From: Nicola Spencer on behalf of Planning.Responses
Sent: 09 February 2018 13:53
To: Karen Garner
Subject: FW: 93 Middleton Road application numbers M/123/17/HH and M/133/17/HH
Attachments: Site and Block Plan Middleton Road V5.pdf; 93 middleton existing elevations.05.12.2017.pdf; Middleton Rd AB 100 7E Version5 08.02.2018.pdf; Middleton Rd AB 100 11C Version5 08.02.2018.pdf; Middleton Rd AB 100 12 Version 5 08.02.2018.pdf

To address your design concerns, I have modified the original scheme shown on applications numbers M/123/17/HH and M/133/17/HH in the following aspects:

SECTION E:E

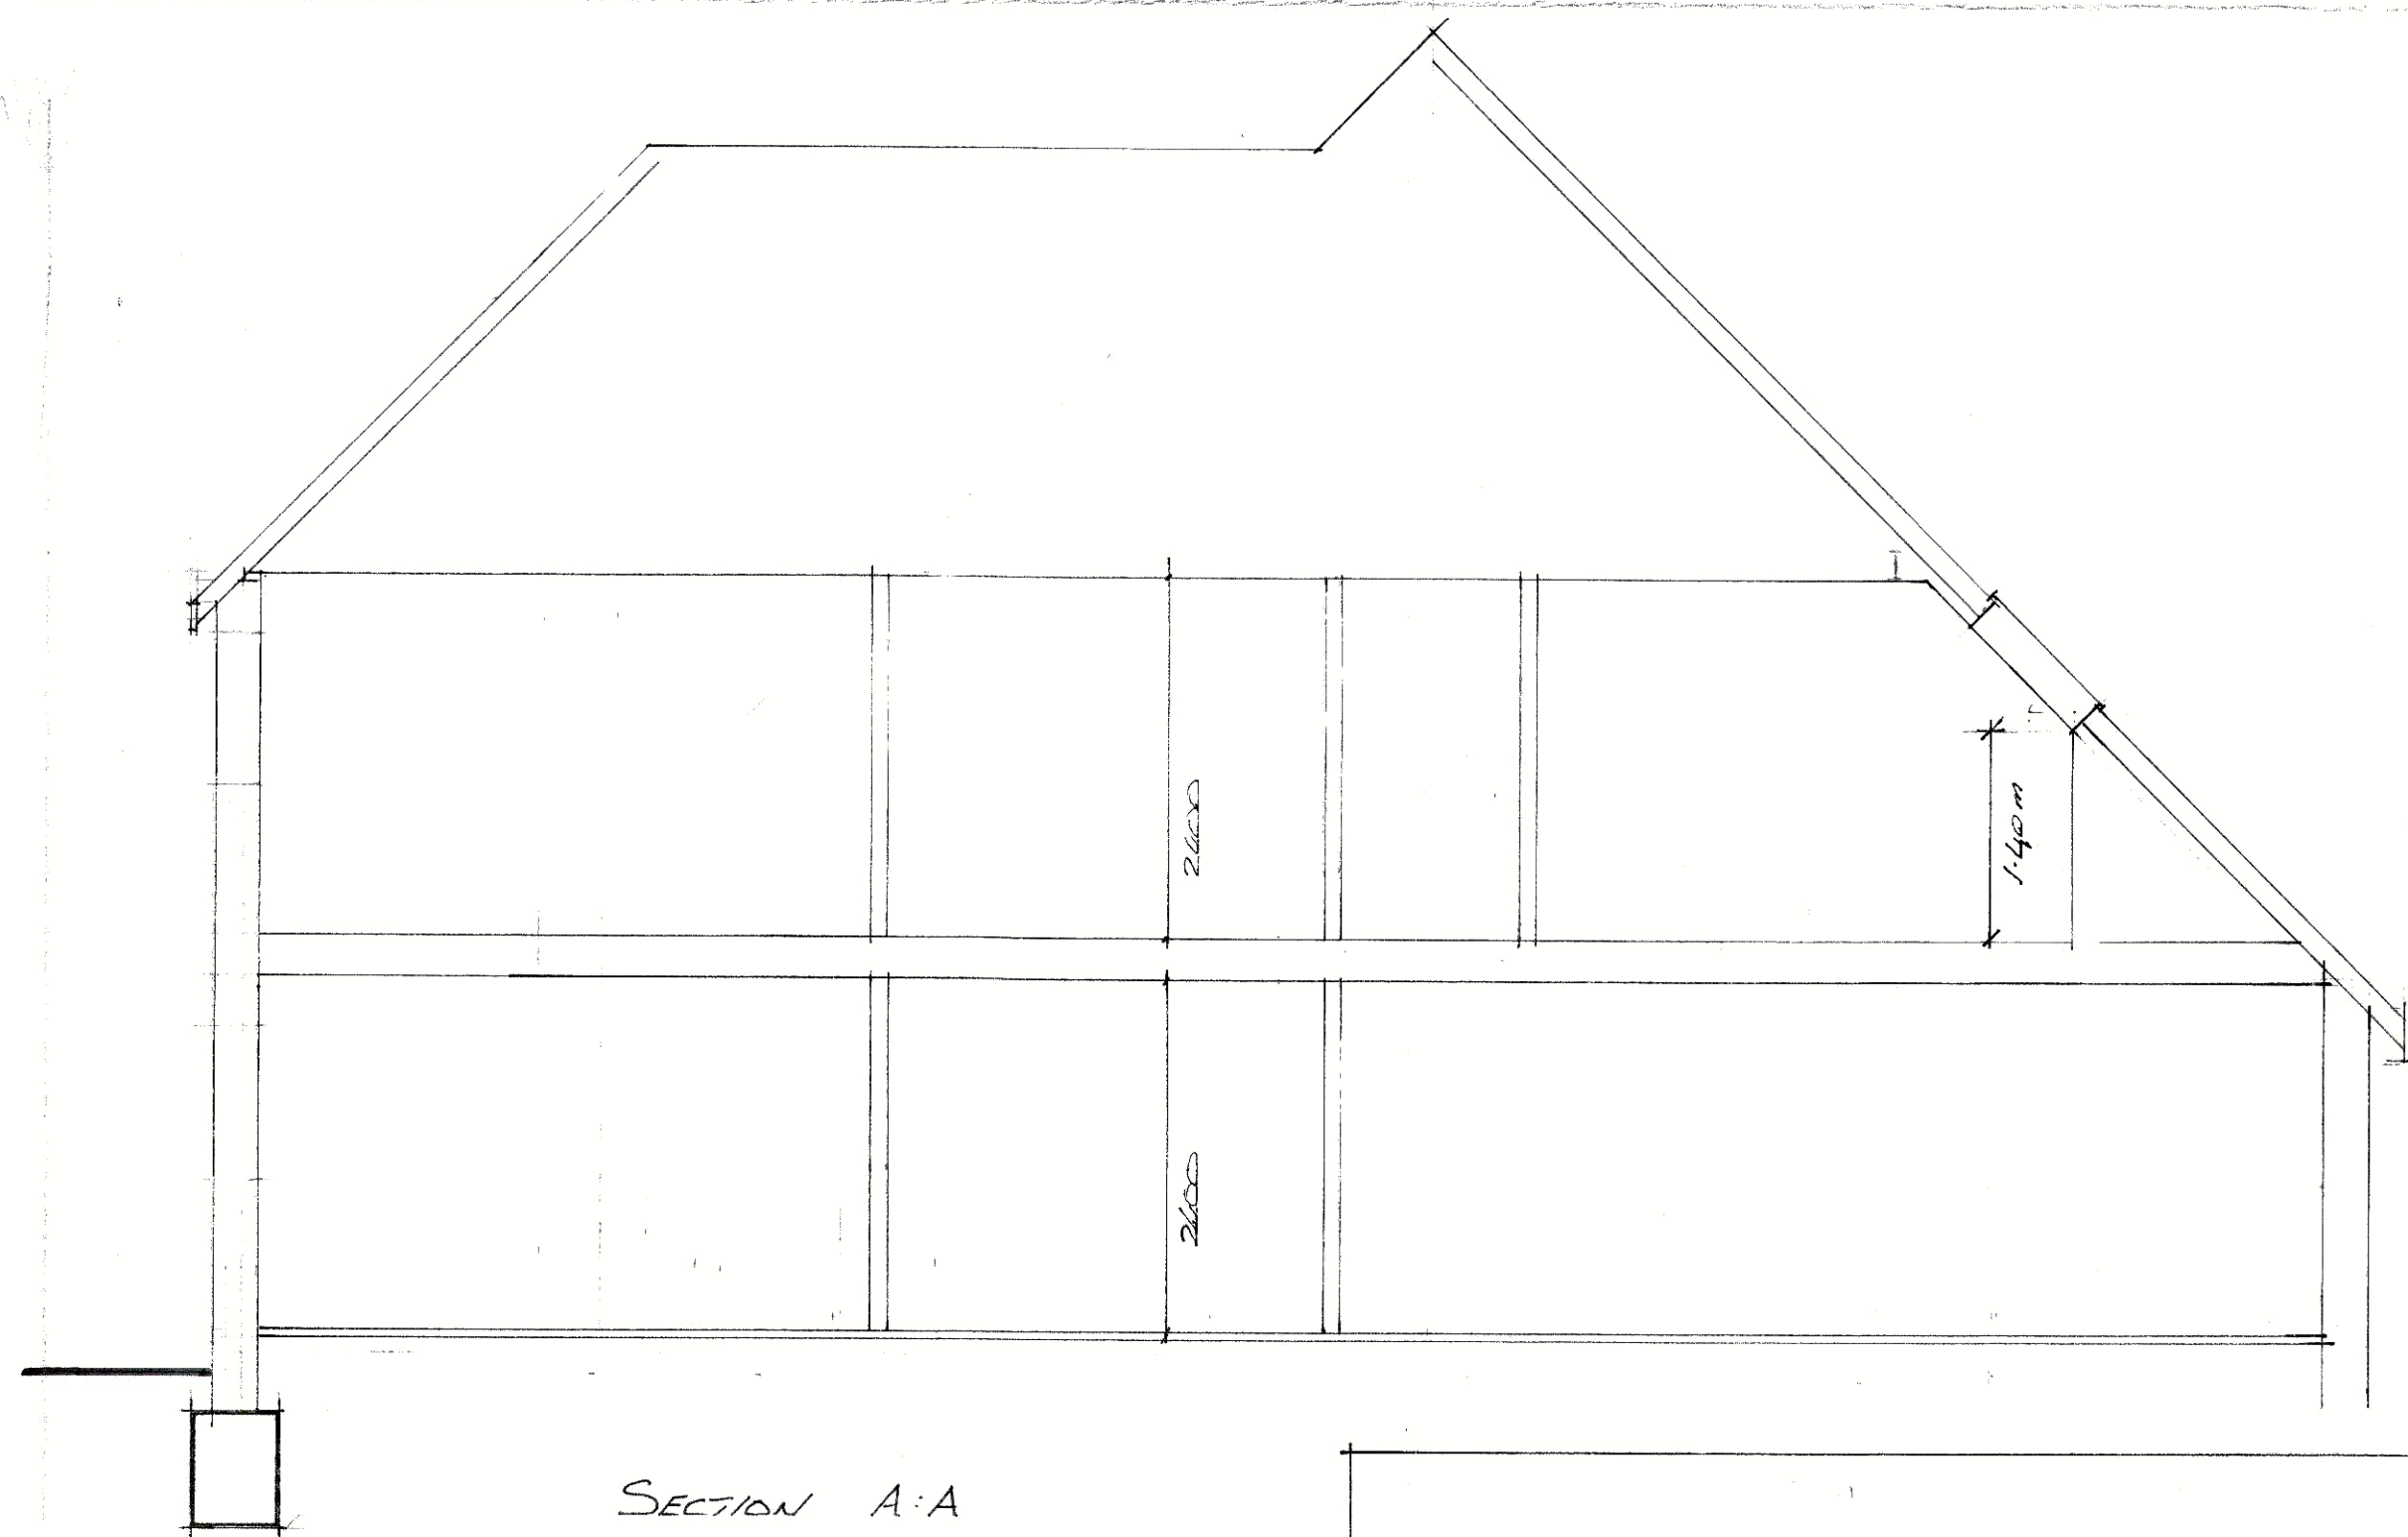
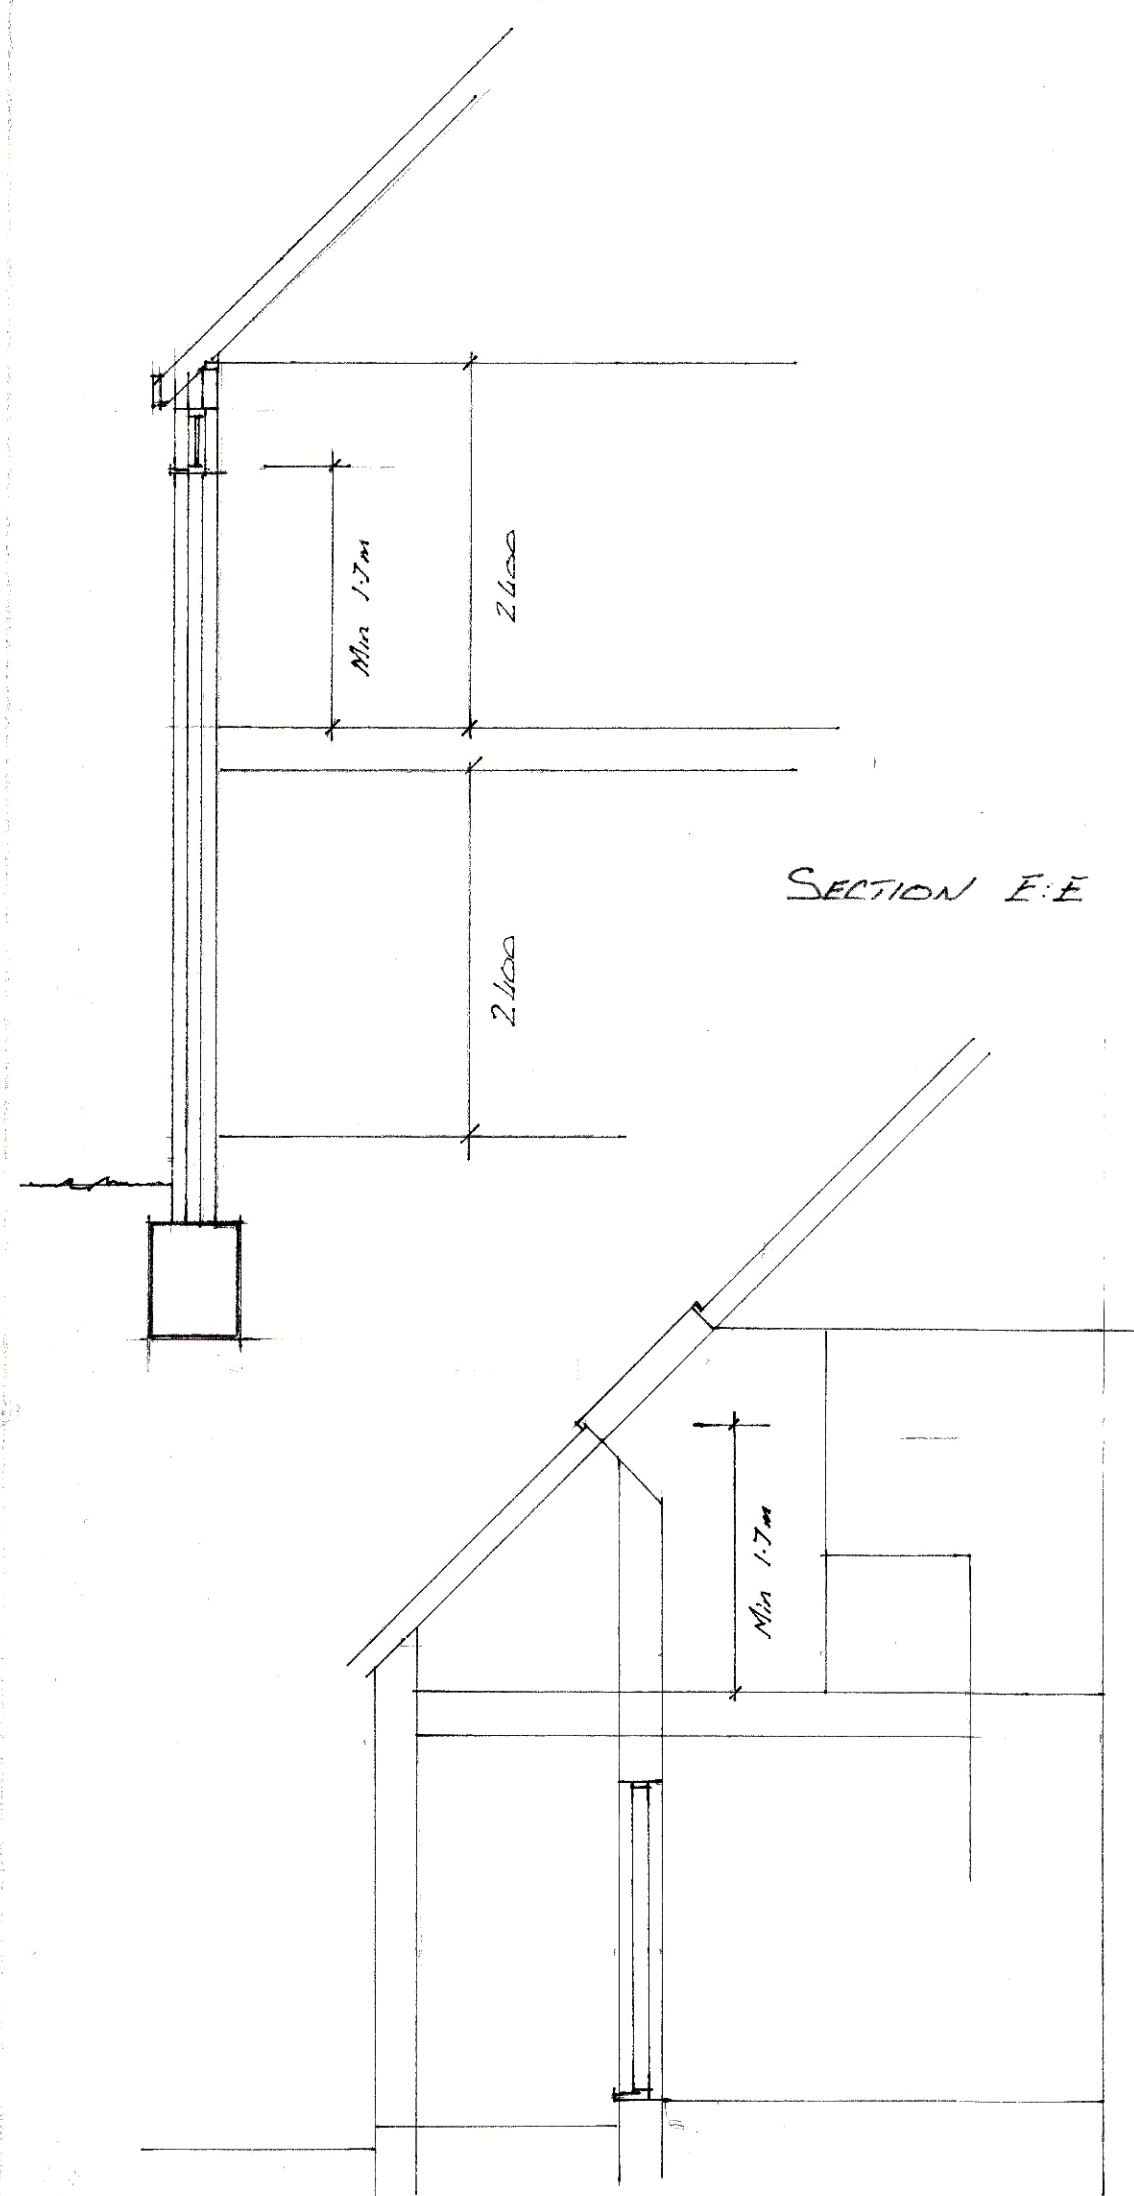
1. Moving the bulk of the extension to the front of the property predominantly on the south west side of the existing building.
2. Removing the cat-slide roof feature shown on the east elevation of the previous scheme
3. Reducing the ridge height on the east side of the building from that shown on the previous scheme
4. Only having one high level window on the east elevation (see section E on drg no AB 100 11C)

DRC N°: AB: 100 12

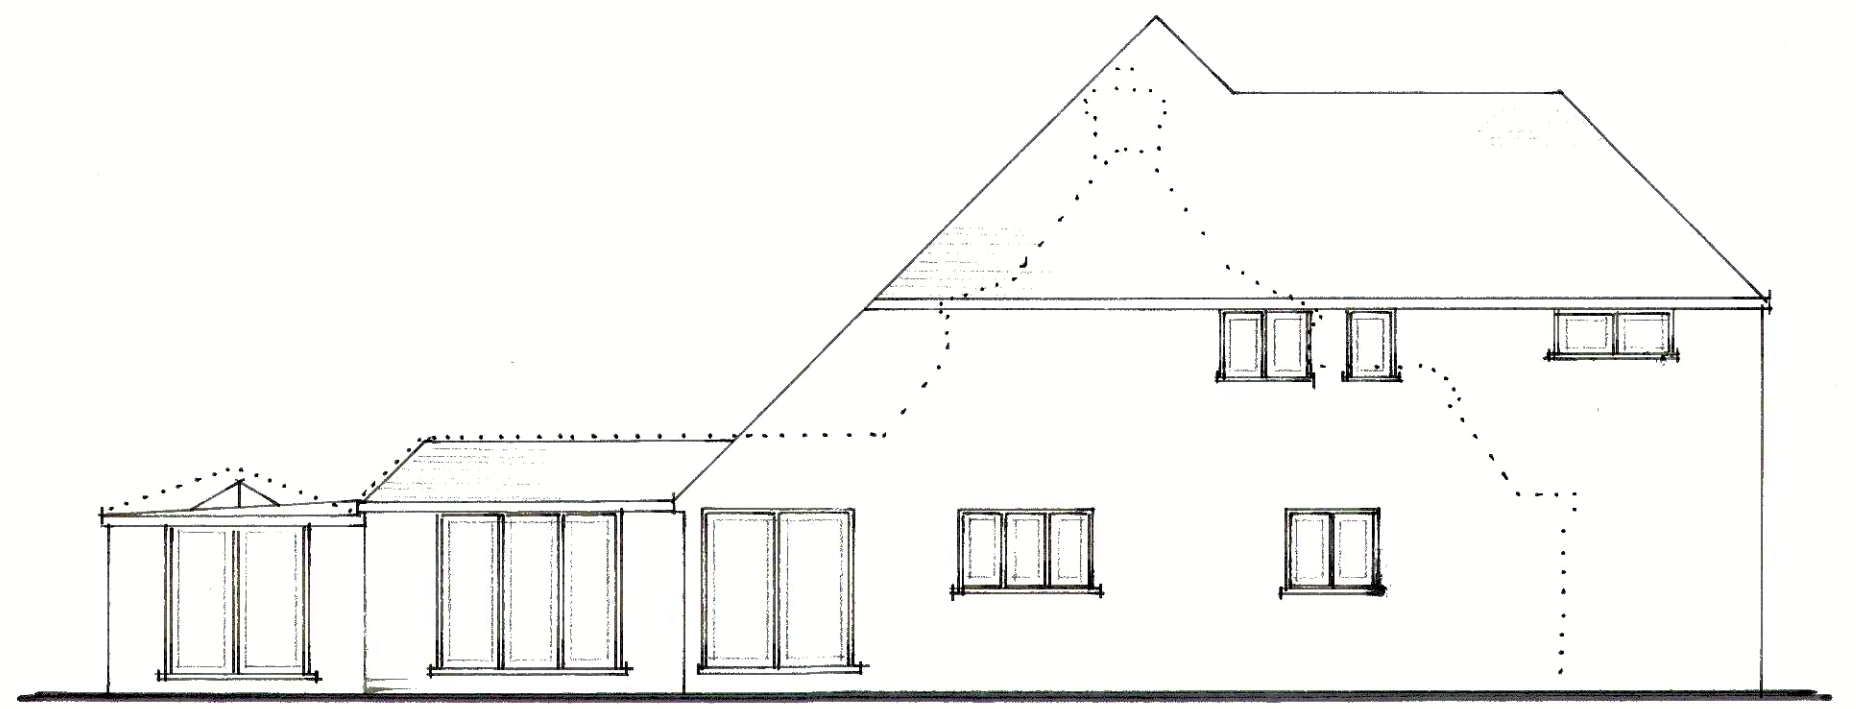
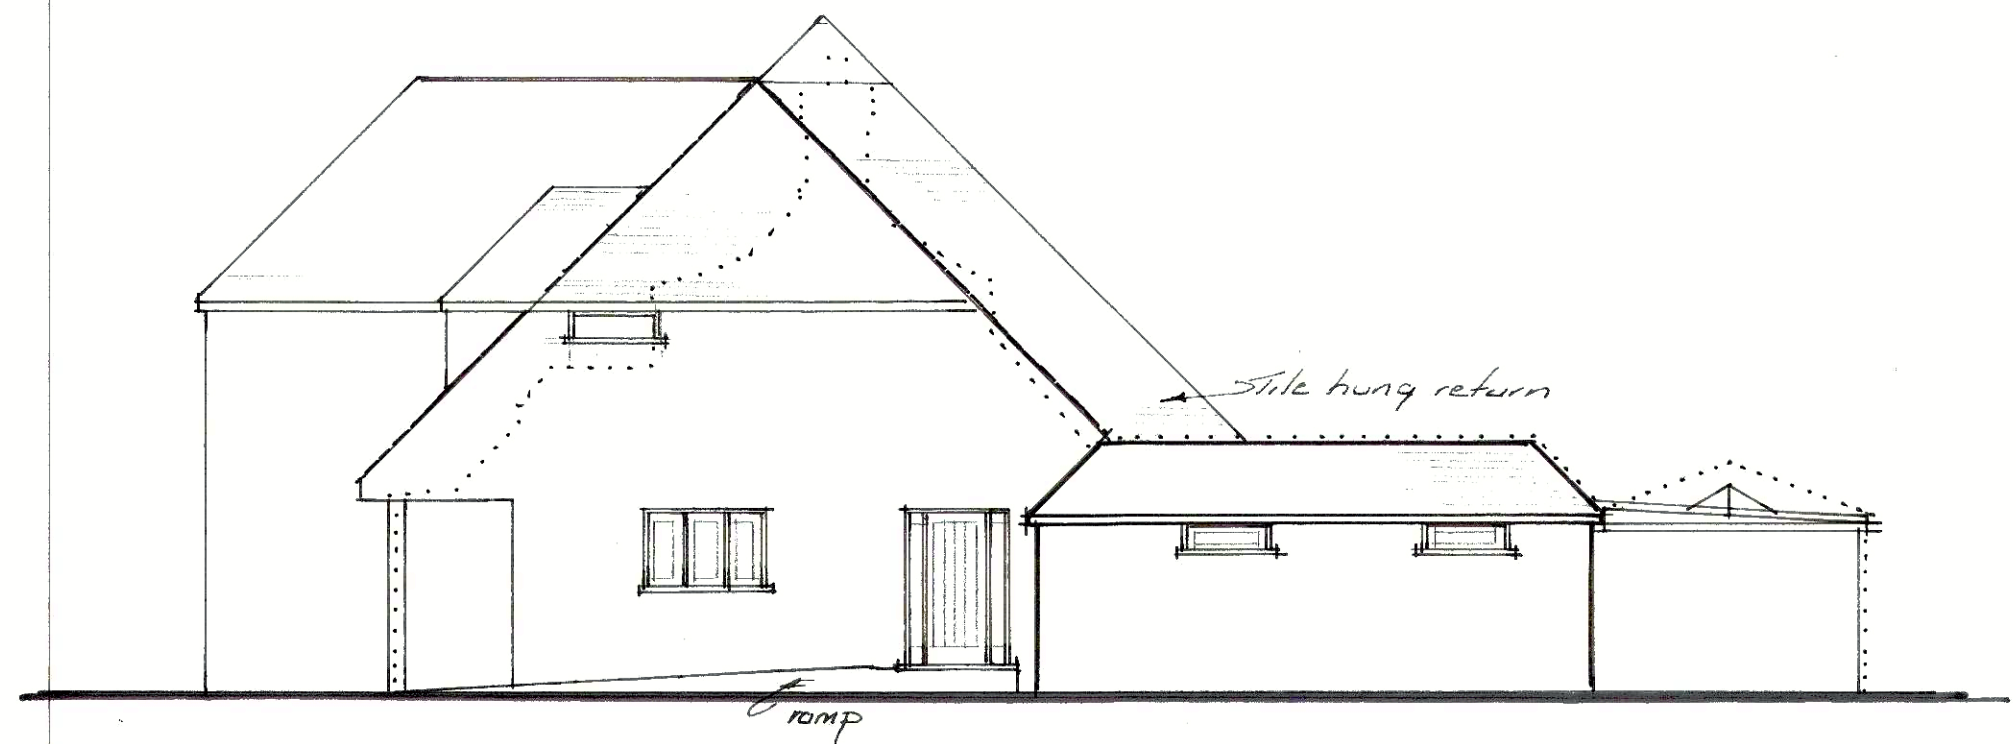
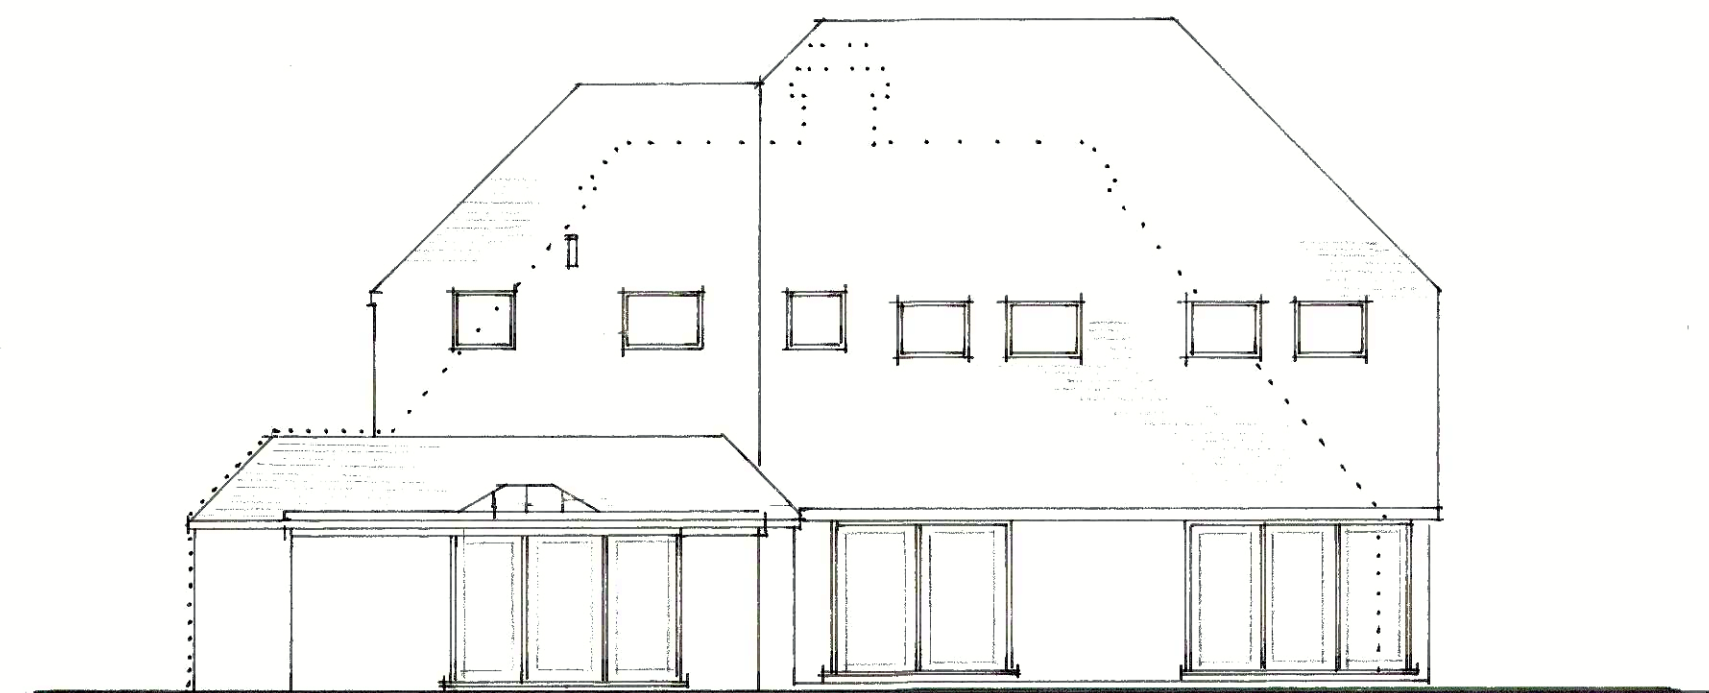
12. I have dotted the existing building outline on drawing number AB 100 12
13. To assist with your review of the street scene, I will send another email with photo shots of the adjoining properties.

7. Not changing the position, structure or windows of the existing annex construction on the east elevation.
8. Moving the rear entrance door further from the east boundary than on the previous scheme

10. Replacing the large windows on the north elevation, as shown on the previous scheme, with velux type windows.
11. Lowering the roof of the conservatory by constructing a flat roof structure
